Online Comment

Application H14-1032-21
Location Crossgate Lane Pinchbeck Spalding PE11 3XW
Proposal Residential Development - 16 Dwellings - outline approval H14-0912-17

Name Angela Doherty
Address Housing Strategy

SITE PLAN 1:500

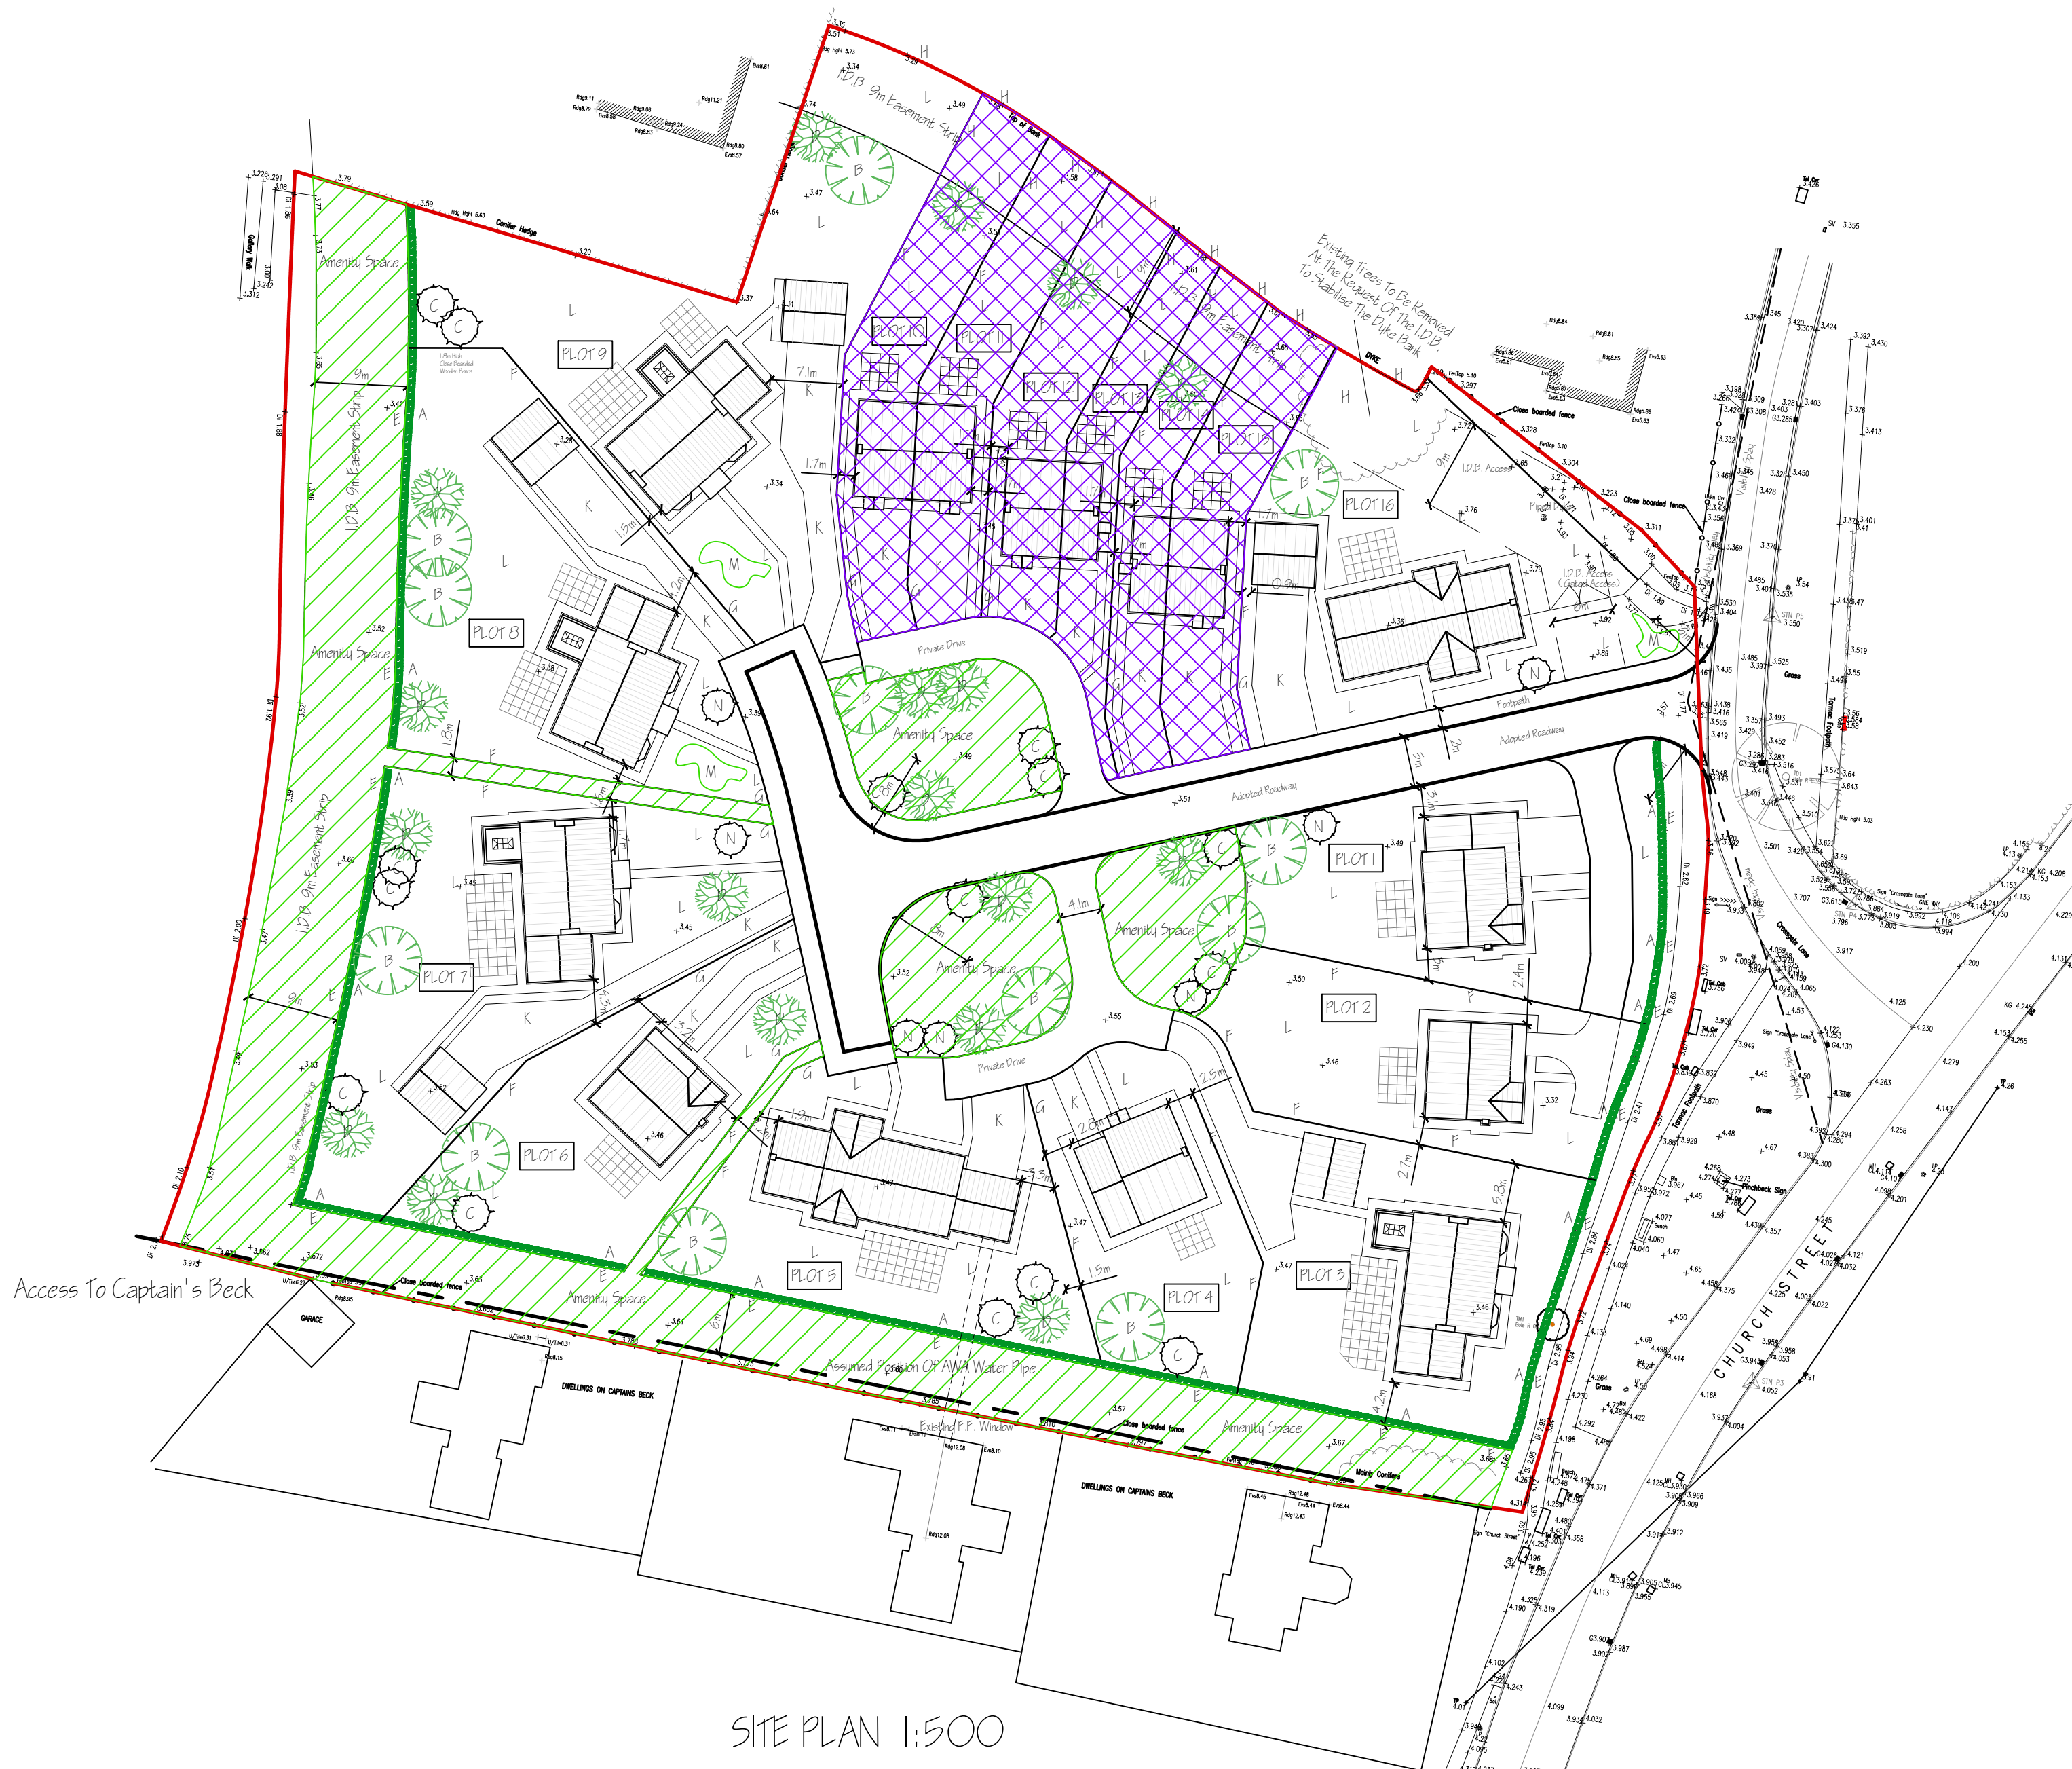
Within this Reserved Matters application the applicant provides plans for plots 10-15 labelled affordable housing. If all 6 of these are provided as affordable housing this equates to more than the minimum 25% of the development. Can planning check with the applicant what is being proposed? y. For these affordable dwellings the applicant does not state the tenure and proposes for them all to be 3 bedroom houses. To meet needs and adhere to local and national policy the applicant should consider amending the plans to deliver 4 affordable homes comprising of 3 Rented- 1 x 1 bed house and 2 x 2 bed houses and 1 Shared Ownership- either a 2 bed or 3 bed house.
